**RFI**

RFI #: 161  
Date: 6/25/2012  
Job: EB-02 Keller Springs Lofts  
Phone: 877-777-5115

Subject: Electrical Outlets Moved for Code

Drawing: Electrical Unit Plans  
Cost Impact: None

E-2.5

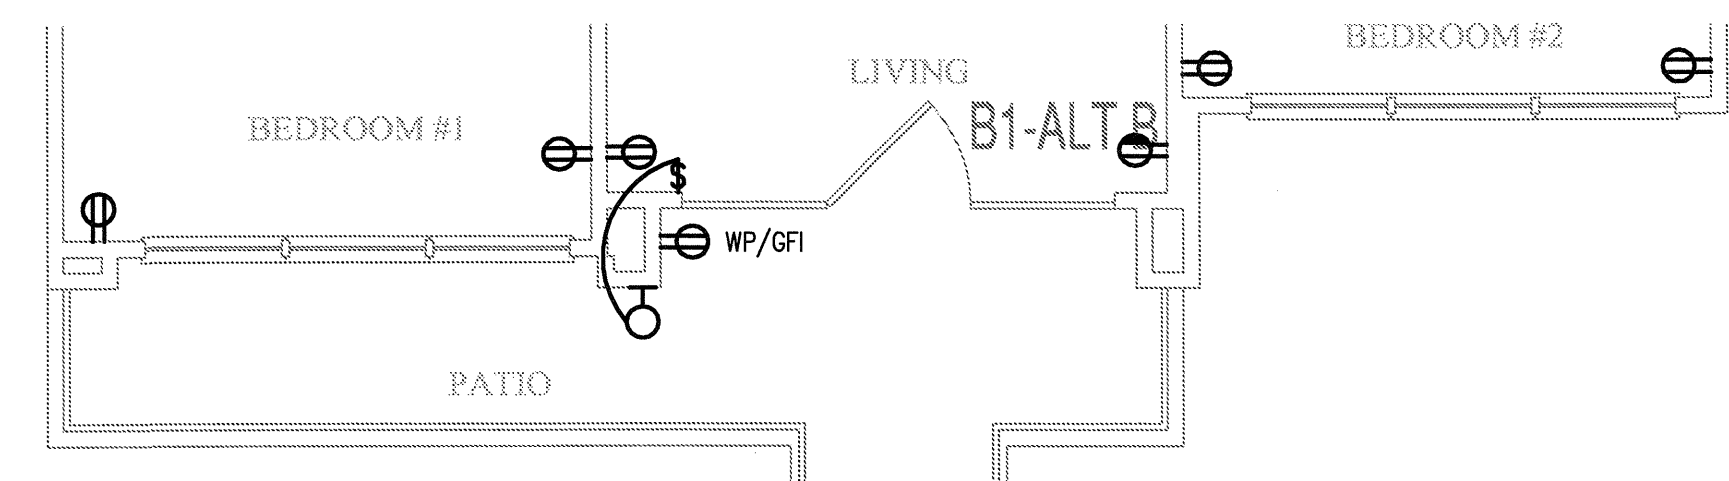
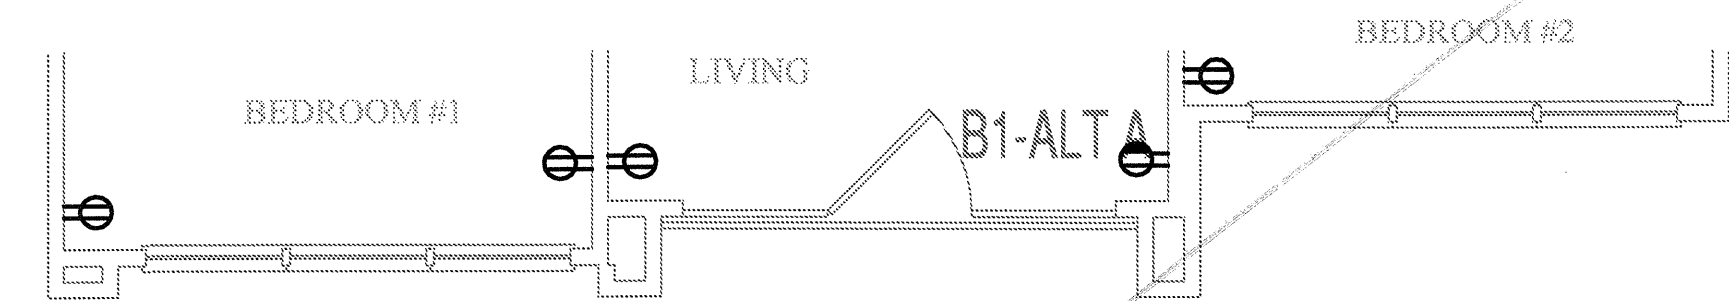
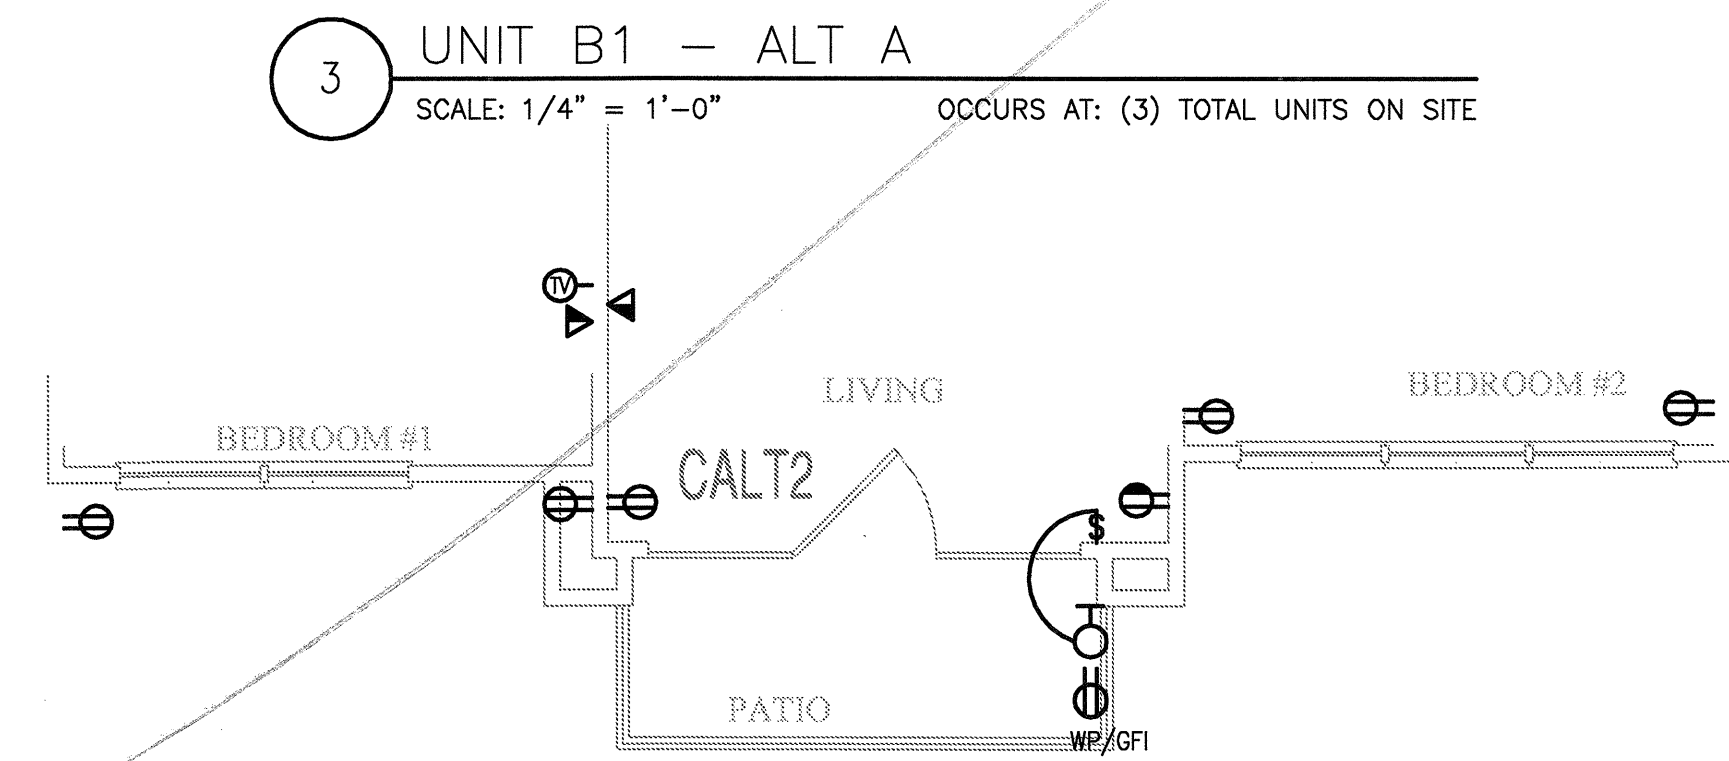
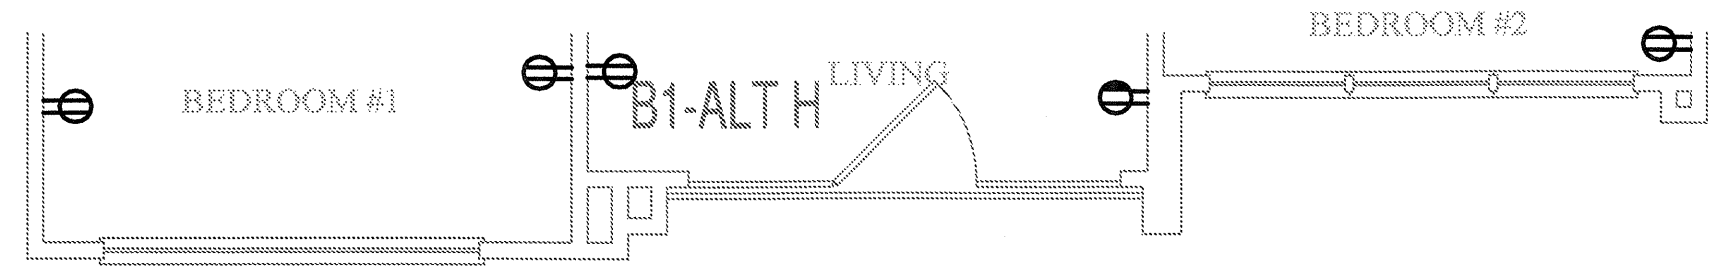
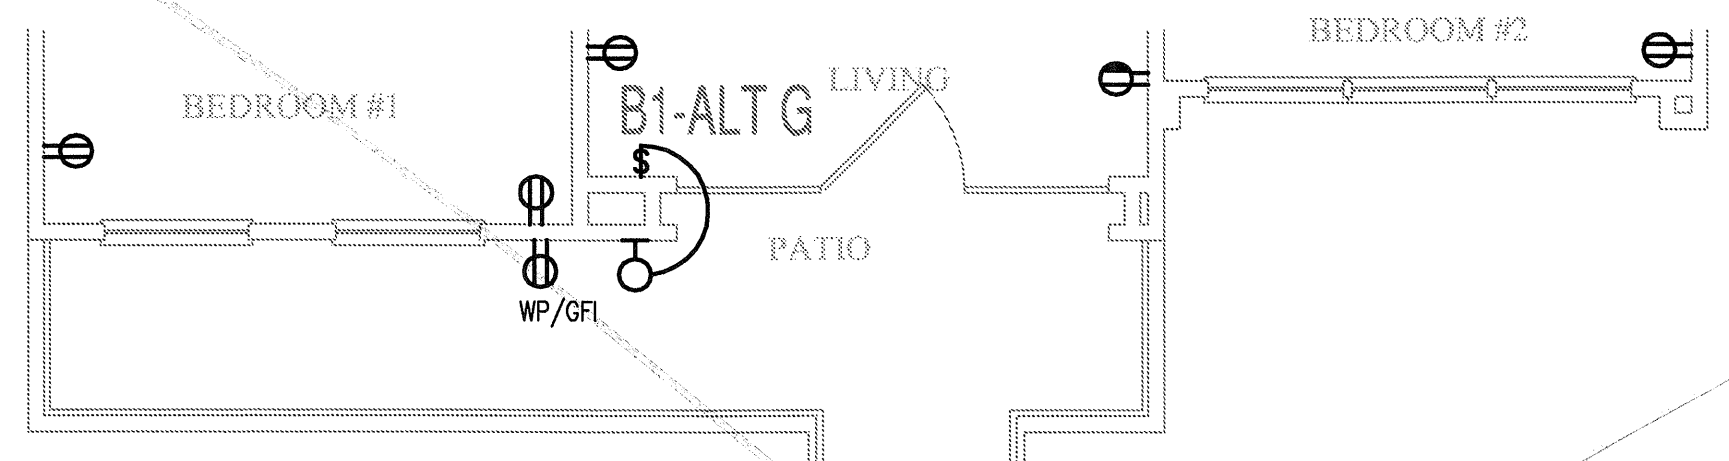
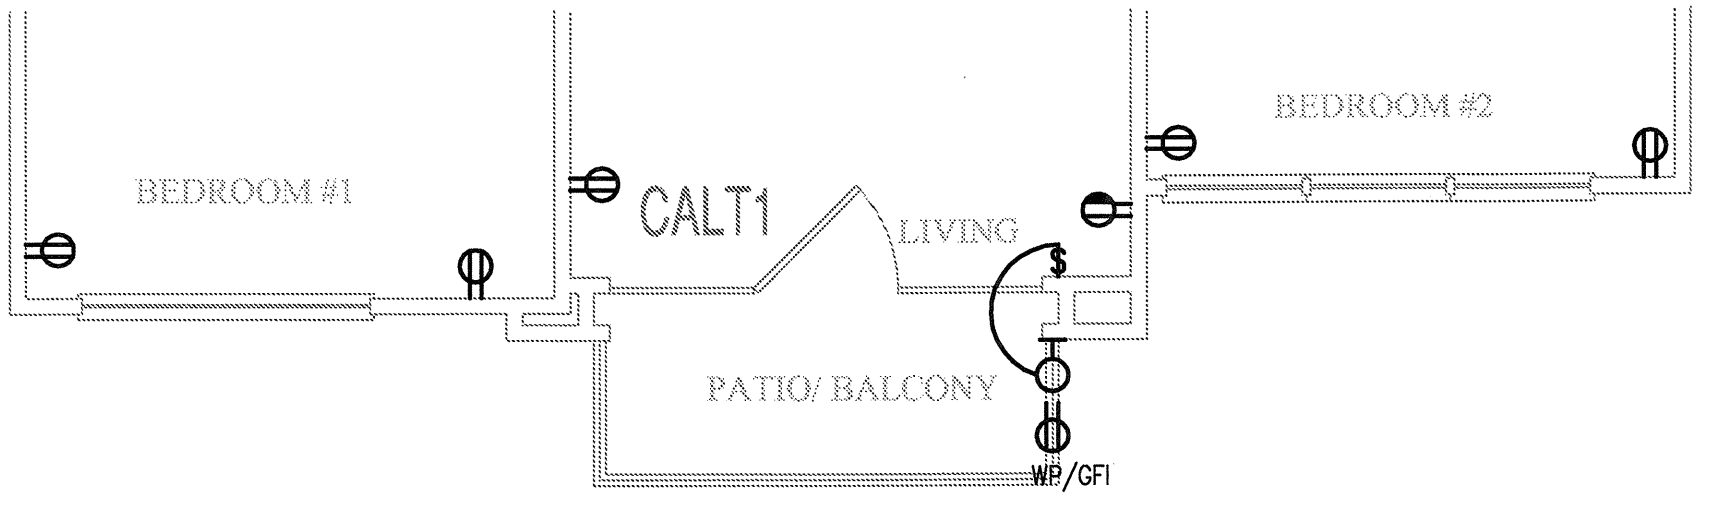
**Request:** We had an issue at another job where some receptacles needed to be moved in bathrooms due to code. Please check and see if this issue will need to be addressed at this job and revise plans if needed.

Reference the attached pdf's showing the correct outlet locations.
